Portishead Branch Line (MetroWest Phase 1)

9.15 ExA.CAH1.D3.V1 – Applicant's Oral Case and response to Representations at the Compulsory Acquisition Hearing 1 (CAH1)

The proposed Portishead Branch Line (MetroWest Phase 1) Order

Applicant's response to Representations at the Compulsory Acquisition Hearing Held on 4 December 2020 at 10am

DETAIL A
Scale 1:150

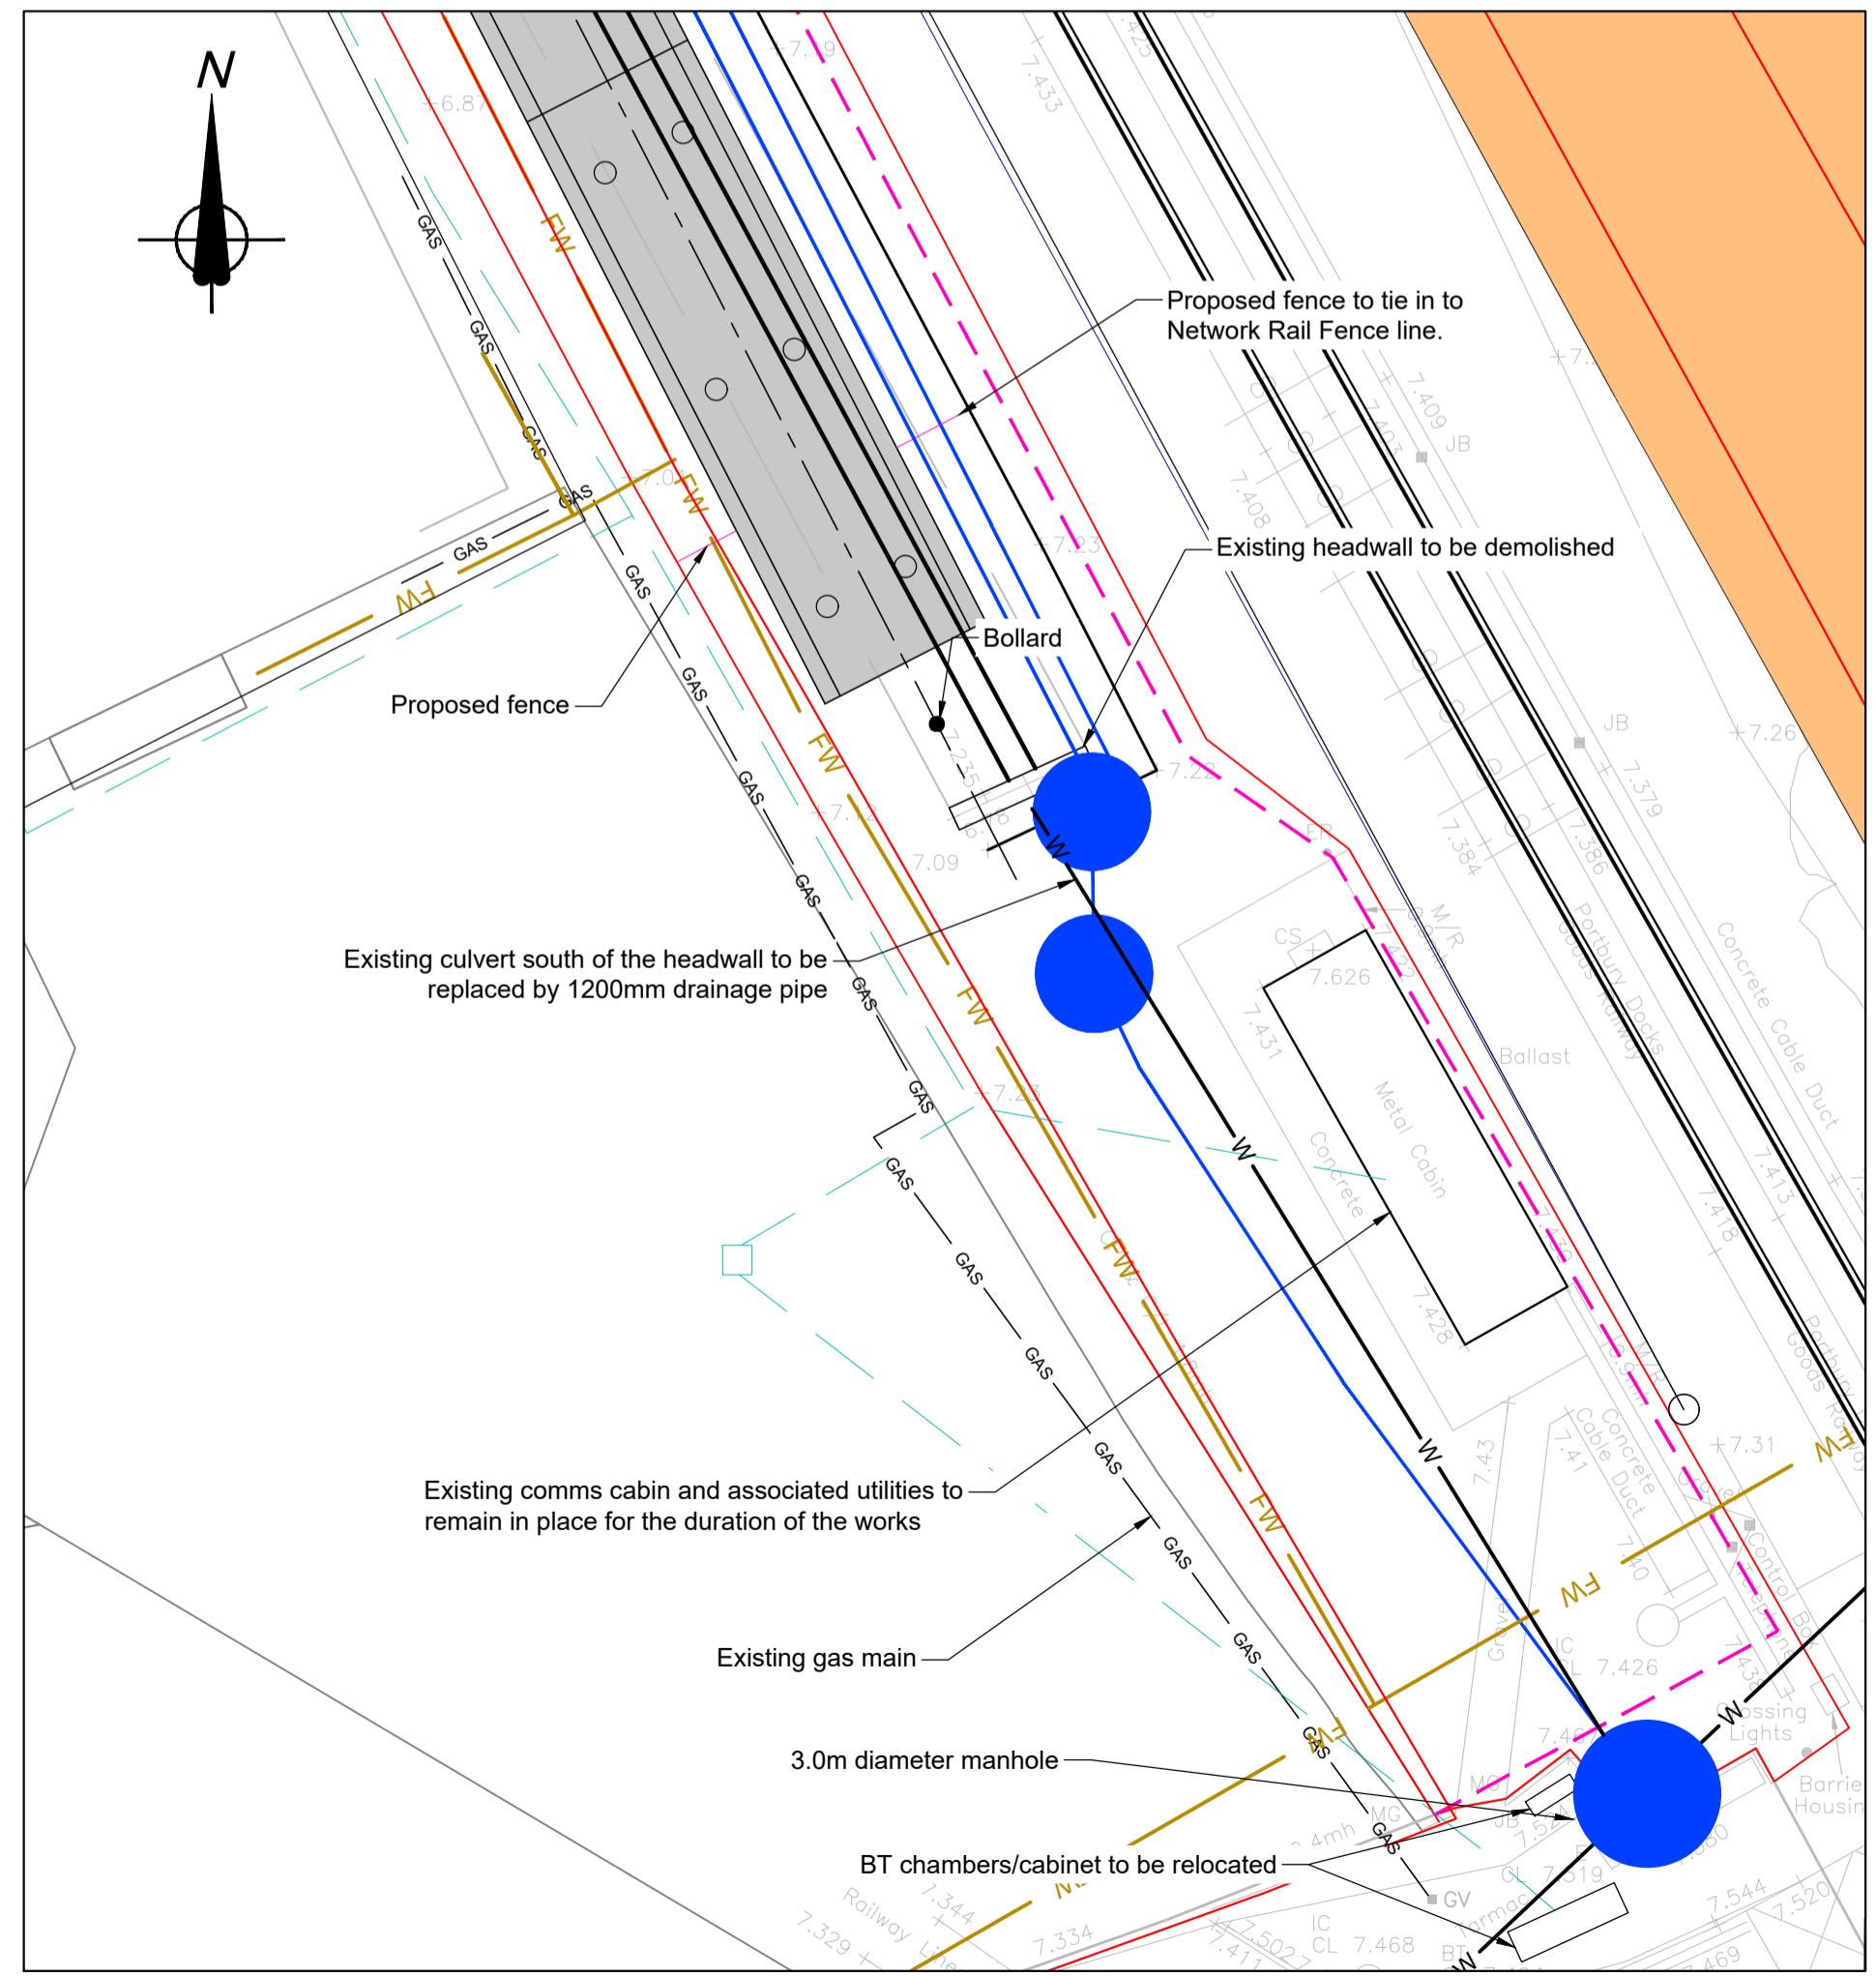
2.	ExA Panel	In relation to Work No 27: This relates to the provision of an alternative crossing by Ashton Vale Industrial Estate. There is uncertainty about whether this work will or will not be provided. The Applicant's response in a letter to Babcock on 21 August stated that the crossing would follow later if built. How does this meet the test set out in s122? If the ramp is built later could this not be done under Network Rail's permitted development rights?	In relation to the test in s122, the land required for the bridge itself is held by Network Rail. Prior to submission of the Application, there was a possibility that the Applicant needed new rights over land comprising the Babcock Estate. This was because the Applicant felt it could not meet the tests in s122 in relation to Babcock's land. The ramp improves accessibility for pedestrians and cyclists at times when the Ashton Vale Road level crossing is closed due to MetroWest services crossing Ashton Vale Road, but does not provide so significant an improvement that the need for it is sufficiently compelling to justify compulsory acquisition of new rights over Babcock's adjacent land. In terms of land in the Order lands on which this work would be located, it is existing operational land held by Network Rail. Network Rail's land is in the Order in any event and the Applicant has already adjusted the order land boundary to remove Babcock's land. As the work is to facilitate an improved highway network or permissive way it may be that	The Applicant has no further representations to add.

Ref:	Question/ Representation by:	Questions/Issues Raised at the CAH	Applicant's Response at the CAH	Applicant's Written Response
			development rights could not be relied on. The Applicant felt it was better to keep the work in the Order to ensure that is has the planning permission ready to construct the ramp.	
			The Applicant did not feel it however there was a compelling case sufficient to seek powers to divert utilities serving Babcock in to Babcock's land. In the face of Babcock's likely objection to powers being sought over its land, it was felt appropriate to not seek those powers. There are planning justifications to keep the work in the Order as, if agreement is reached with Babcock, then the ramp would be provided. Bristol City Council is keen for the ramp to be provided for pedestrian access to Ashton Vale Road at times when the level crossing is closed due to the increased number of train movements arising from the MetroWest services. However the need for the ramp is not so compelling that it justifies seeking compulsory new rights over Babcock's land.
